WEST SUSSEX COUNTY COUNCIL CONSULTATION

TO:	Arun District Council FAO: Anita Gardner
FROM:	WSCC - Highways Authority
DATE:	29 March 2019
LOCATION:	Land Adjacent 1 Orchard Way Fontwell BN18 0SH
SUBJECT:	WA/18/19/PL Erection of 2 No. detached dwellings, adaptation to existing crossover & new driveway (resubmission following WA/58/18/PL).
DATE OF SITE VISIT:	
RECOMMENDATION:	Advice
S106 CONTRIBUTION TOTAL:	£ N/A

Figure 3. Proposed site layout, Orientated North

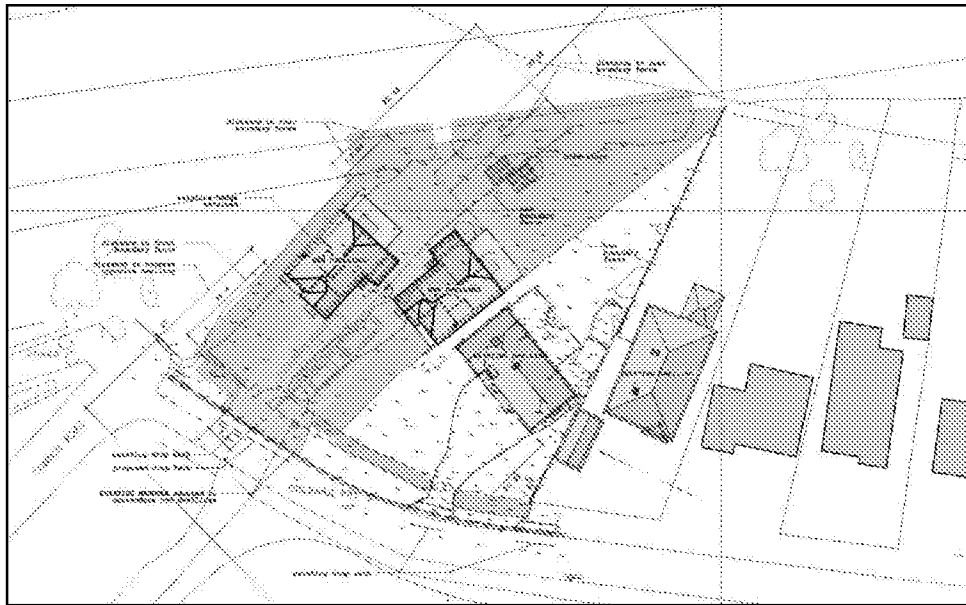
The westernmost proposed building is shown to be erected onto part of the publicly maintainable highway and therefore before such a use of that land can commence, the land will need to be legally "Stopped Up".

In order for the land to be incorporated into the site, the highway rights would need to be formally removed by way of a Stopping Up Order. The process is controlled by Section 247 of the Town and Country Planning Act and approval would have to be obtained from the Department for Transport. This would be subject to a separate process administered by the Department for Transport's National Casework Team. The Highway Authority along with other statutory undertakers and interested parties would be consultees in this process. There is also no guarantee that this process would be successful.

The proposed dwellings are to use an existing dropped kerb arrangement and extend to allow a shared VCO access for the two properties. The Local Highways Authority (LHA) has independently consulted the Area Engineer for Arun whom has advised that a VCO

Two parking spaces have been demonstrated to serve each dwelling although will less space than the previously submitted proposal; the LHA considers that this provision would be suitable to satisfy the anticipated demands. No turn on site is available to users of this parking area, however due to the nature of Orchard Way it is not considered that this would pose a severe highways safety concern.

I note the presence of a parcel of land in this location within WSCC ownership. This land intersects the dropped kerb access along the frontage of the property where future residents would be required to cross. I advise that the applicant contacts WSCC Legal Services in order to formalise this right of access or with a view to purchase a portion of this land. I have included a plan outlining the extent of WSCC ownership at this location, this is represented by a pink shaded rectangle.
